Memorandum

Re: 36 Waterville St. (017 E015)

I have done a partial review of the building plans for permit #020834 and need the following:

4TH FLOOR PLAN

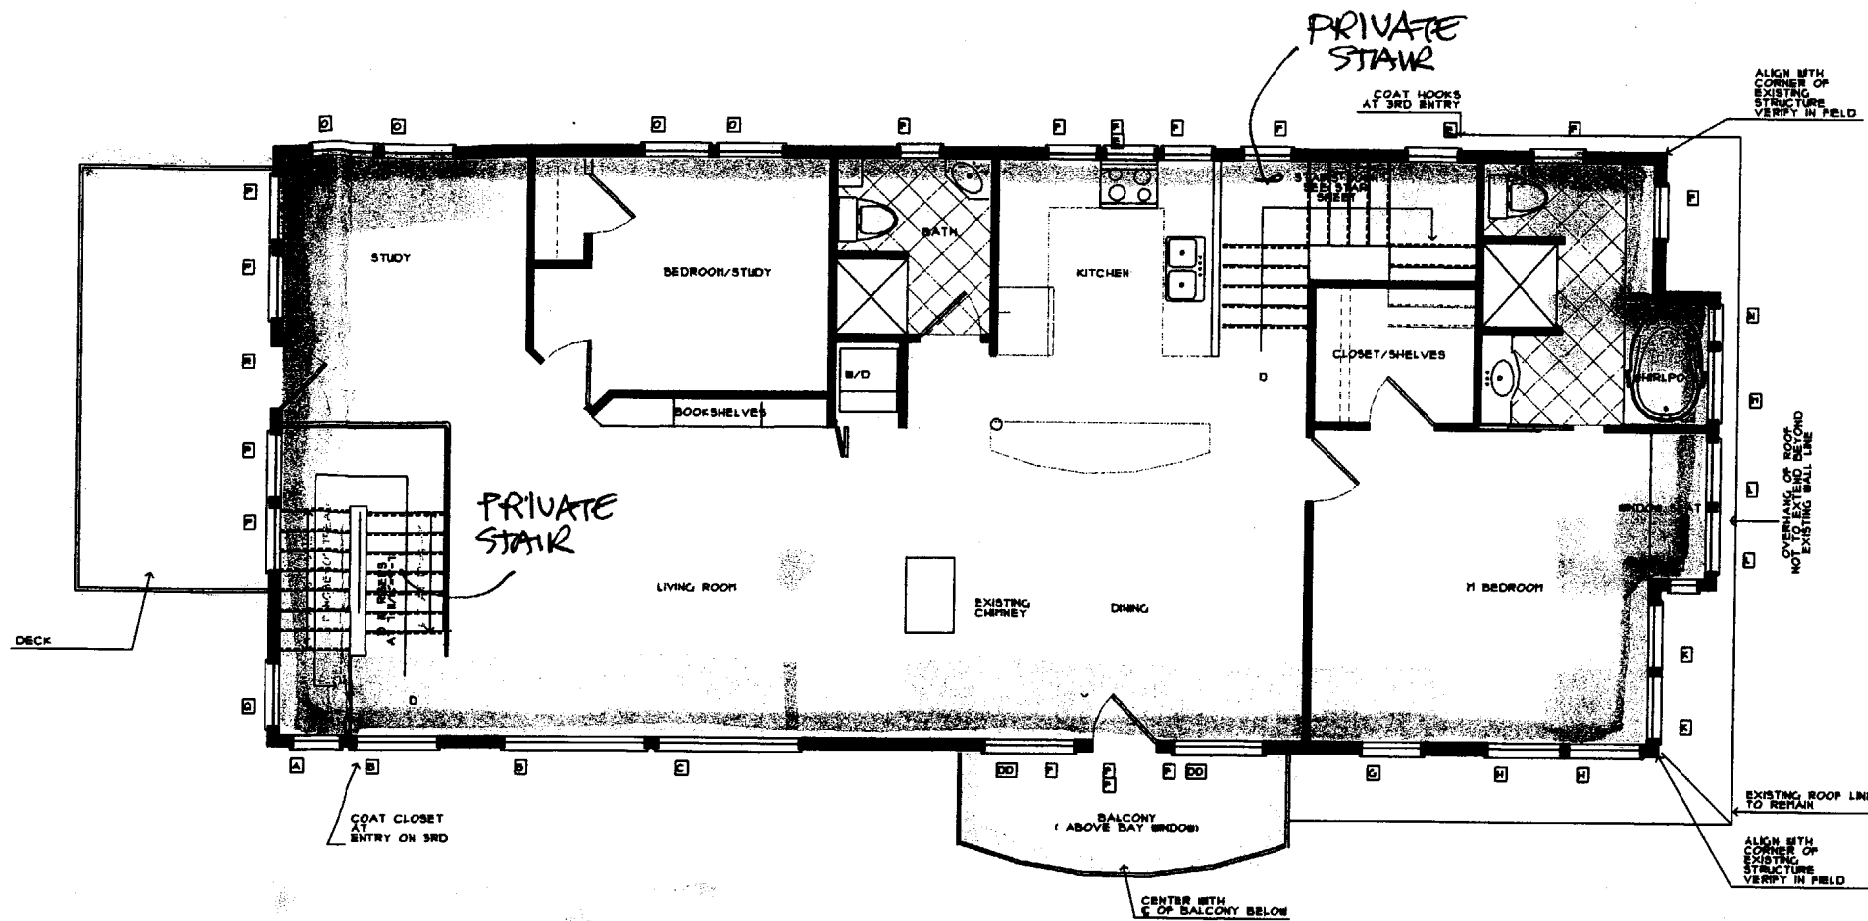
- 1) What percent of the existing basement is 6' above grade, it appears that it's less than 50% .
- 2) The building addition will have to be type 5A construction, please review table 602 of the '99 BOCA Code and provide information on the required fire separations.
- 3) A waiver request for the openings on the North elevation with supporting information.
- 4) What is the actual distance between the two buildings(36 and 40 Waterville)?
- 5) The means of egress stairways and door, Fire rating & Details ?
- 6) Guard rail material/ Details
- 7) Letter from owner with fire suppression commitment.
